CITY OF ALBUQUERQUE

May 13, 2024

**Re: Champion Express Car Wash
211 Unser Blvd SW
Request for Certificate of Occupancy- 30 Day Temp
Transportation Development Final Inspection
Plan Approval Date 2-23-23 (K10D064)
Certification dated 5-8-24**

TRAFFIC CERTIFICATION

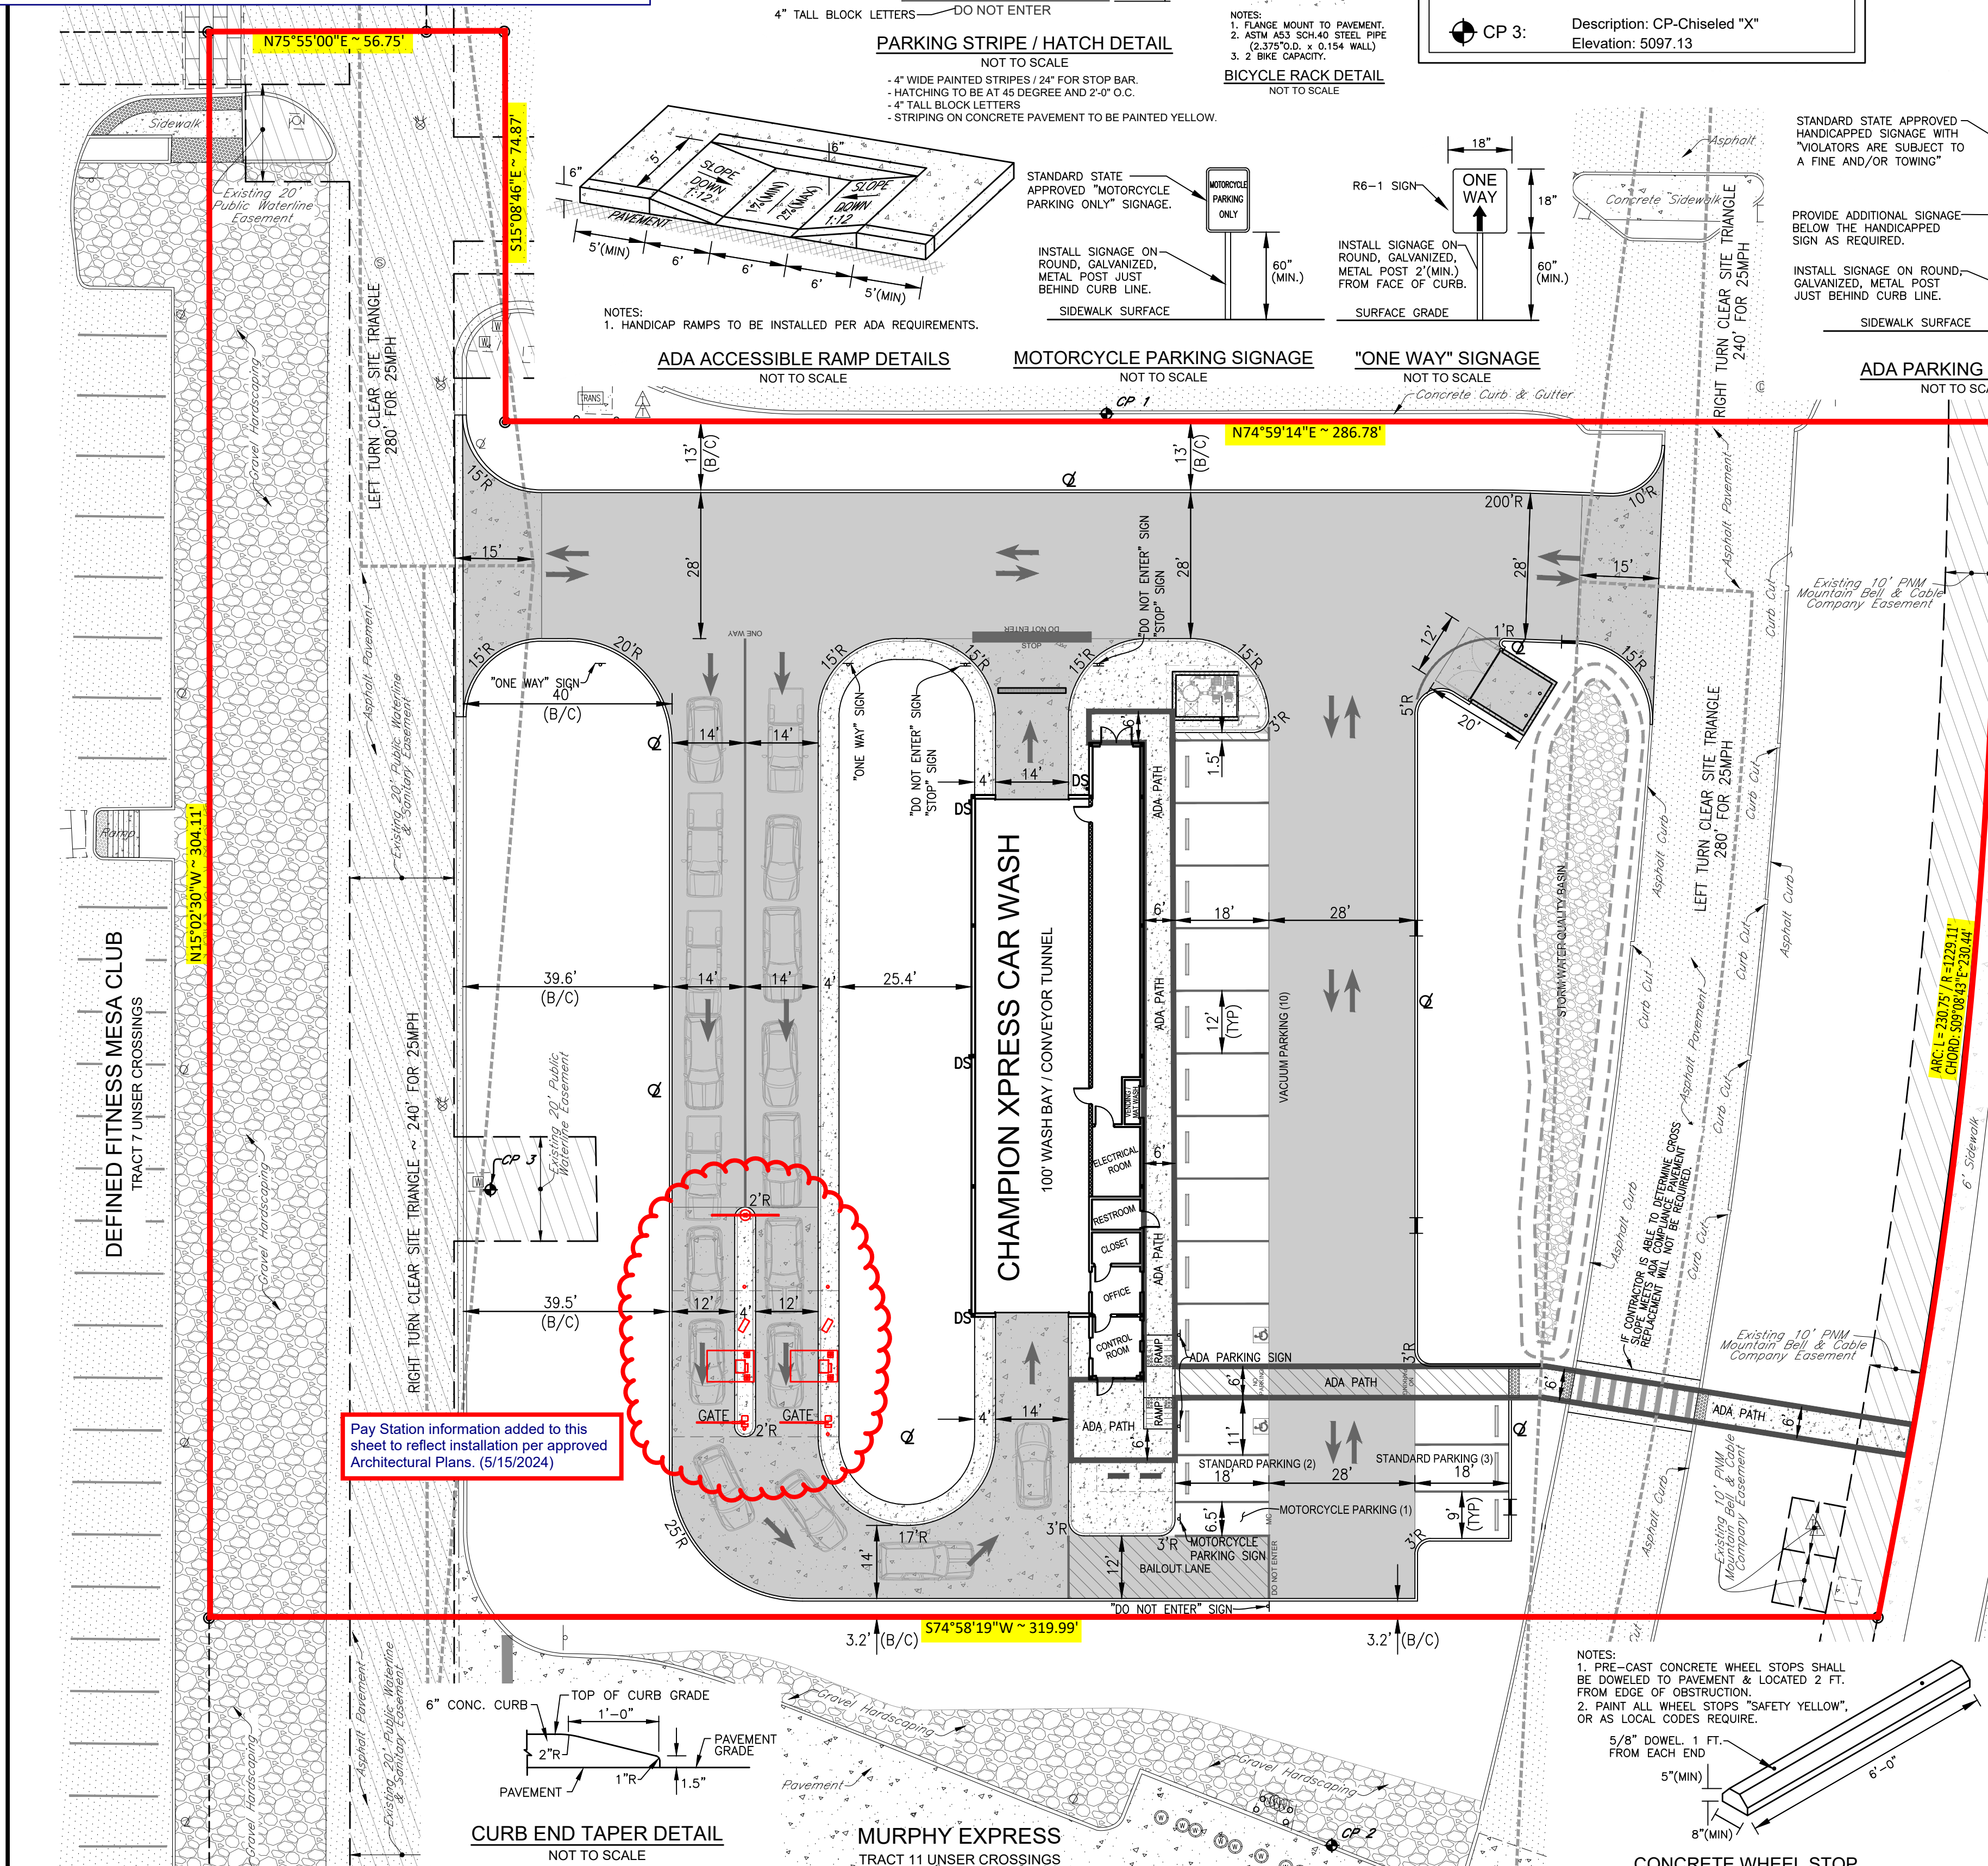
1. There was equipment, in addition to the gate foundation, installed in the sidewalk adjacent to the entry drive that makes the sidewalk impassable. If this is acceptable, please revise the as-built drawing.
